**United Utilities Water PLC  
Developer Services & Planning**  
Warrington North WWTW  
Barnard Street off Old Liverpool Road  
Gatewarth Industrial Estate  
Sankey Bridges  
Warrington  
WA5 1DS

**Your ref:** 3/2015/0649  
**Our ref:** DC/15/2599  
**Date:** 01-SEP-15

**Location: Land adj 97 Woone Lane, Clitheroe**  
**Proposal: erection of 10 dwellings**

PLANNING LAYOUT

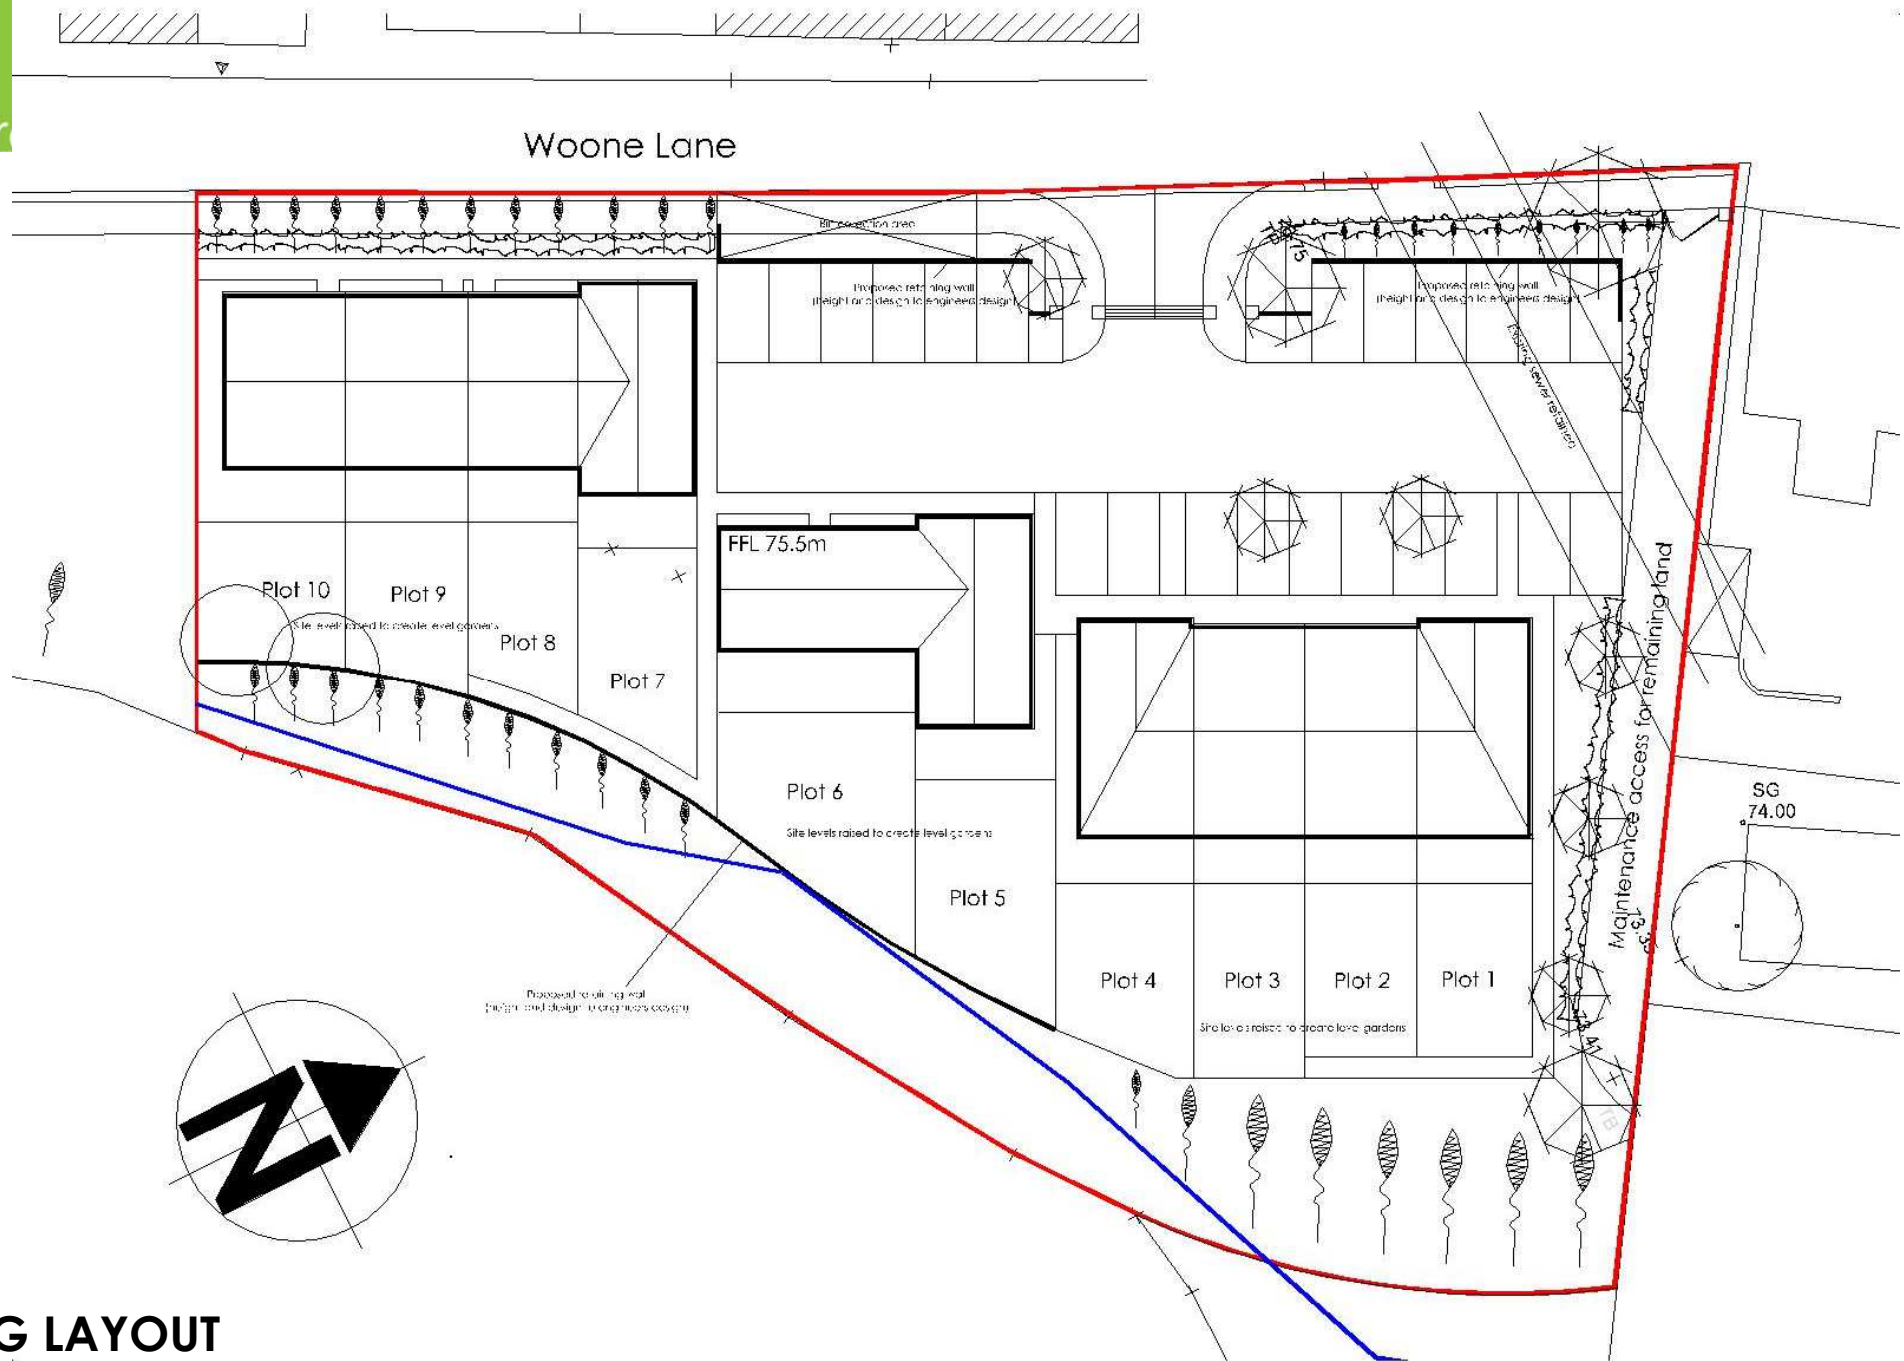
A public sewer crosses this site and we may not permit building over it. We will require an access strip width of six metres, three metres either side of the centre line of the sewer which is in accordance with the minimum distances specified in the current issue of "Sewers for Adoption", for maintenance or replacement.

Therefore a modification of the site layout, or a diversion of the affected public sewer at the applicant's expense, may be necessary. To establish if a sewer diversion is feasible, the applicant must discuss this at an early stage with Daniel McDermott Developer Engineer at
